Our Reference: SYD17/01262 (A19215293)  
DP&E Ref: SSD 8200

**PROPOSED RESOURCE RECOVERY FACILITY - 21 AND 25 DUNHEVED CIRCUIT, ST MARYS**

Reference is made to the Department of Planning and Environment (DP&E) letter dated 11 September 2017, regarding the abovementioned application which was referred to Roads and Maritime Services (Roads and Maritime) for comment.

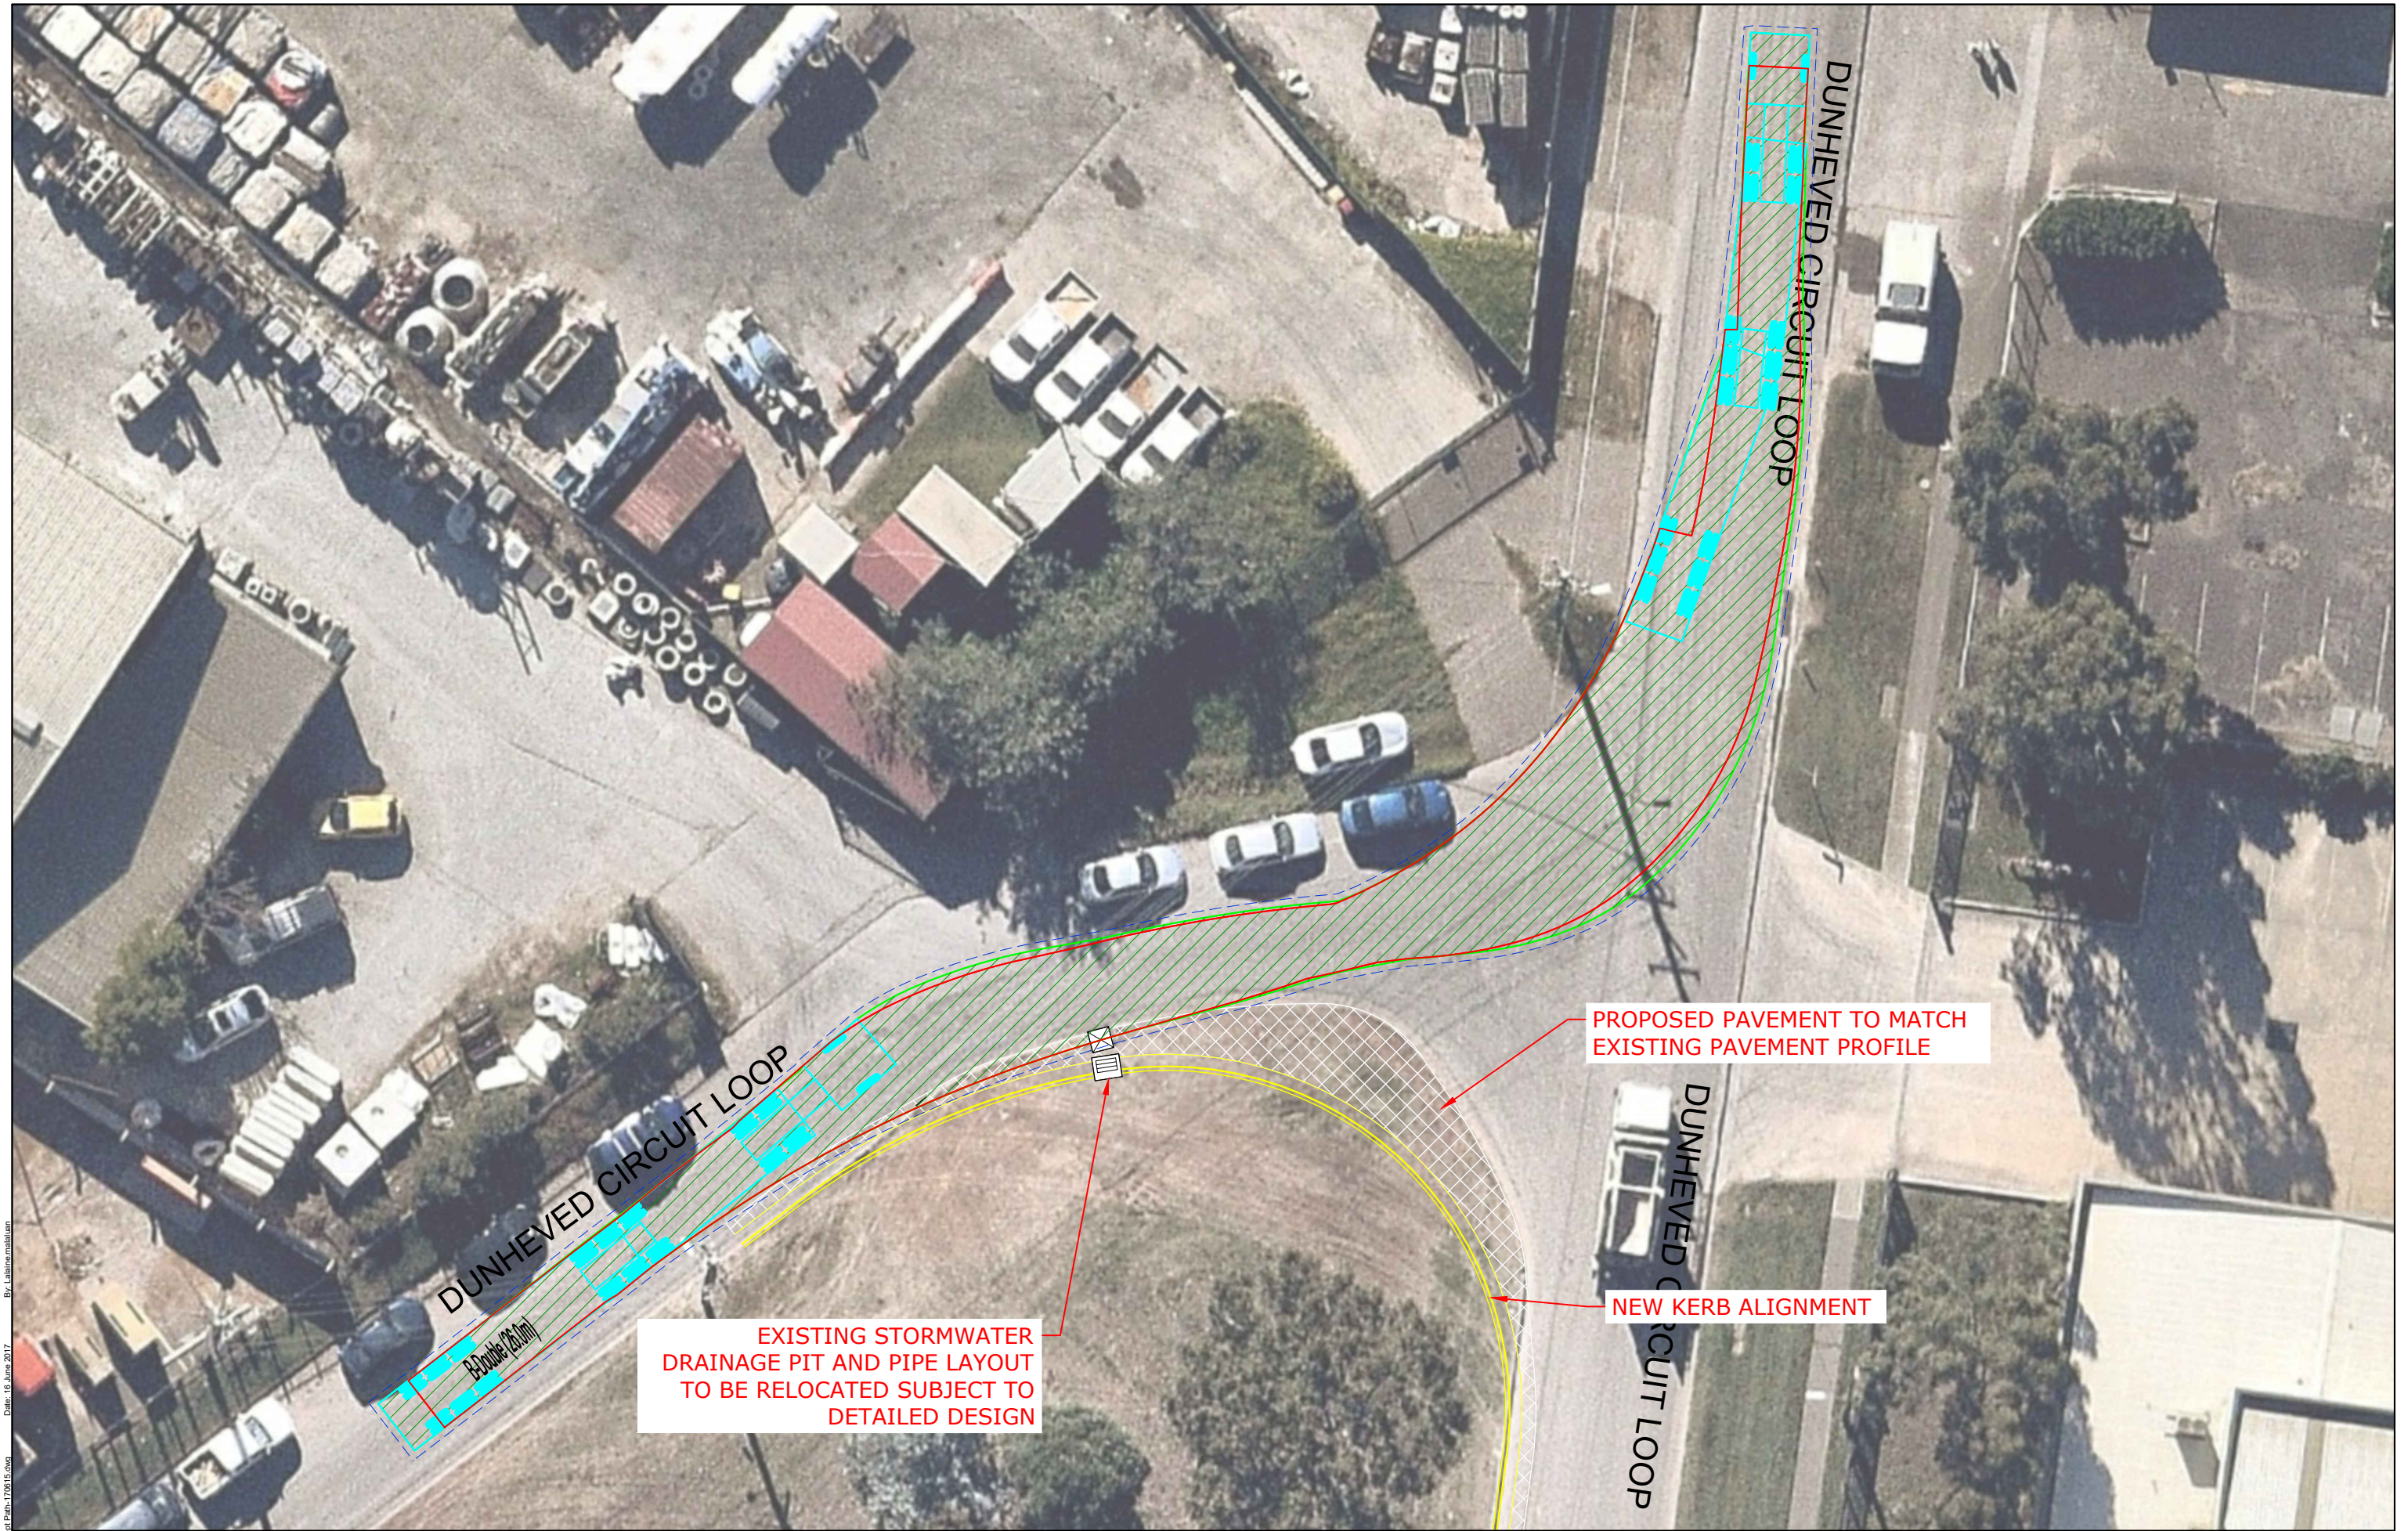
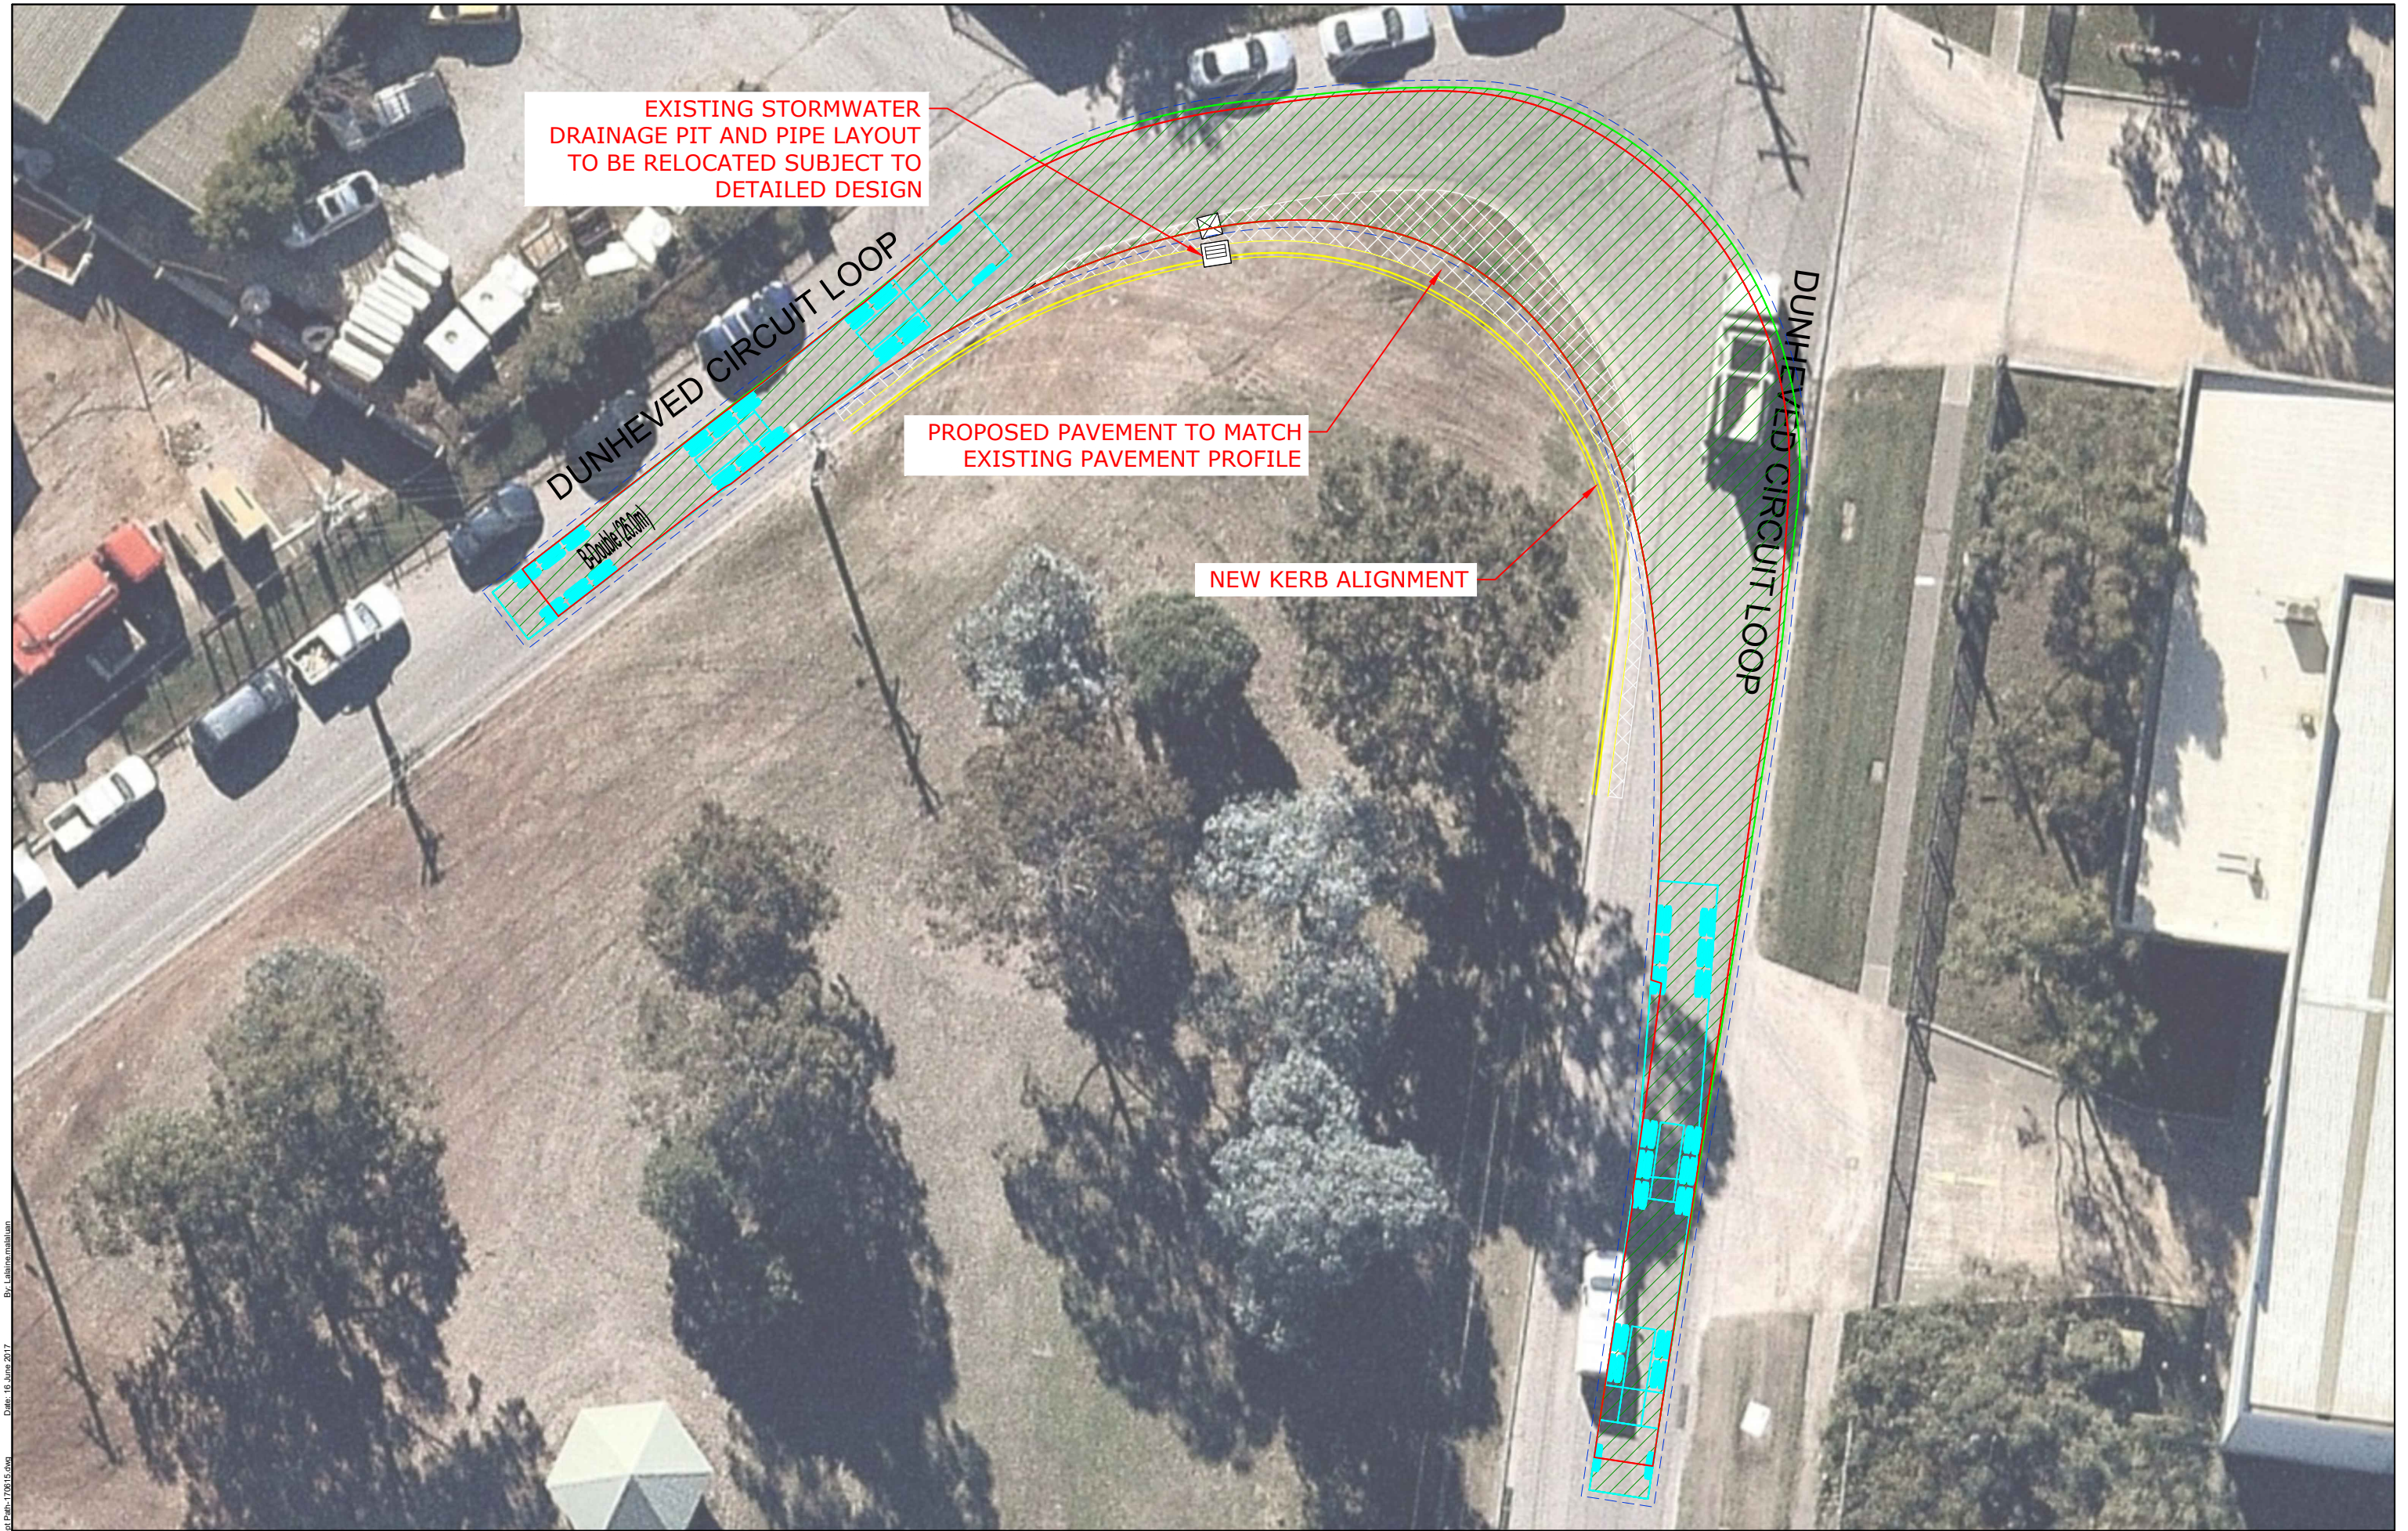
3. The swept path of the longest vehicle entering and exiting the subject site, as well as manoeuvrability through the site, shall be in accordance with AUSTROADS. In this regard, a plan shall be submitted to Council for approval which shows that the proposed development complies with this requirement.
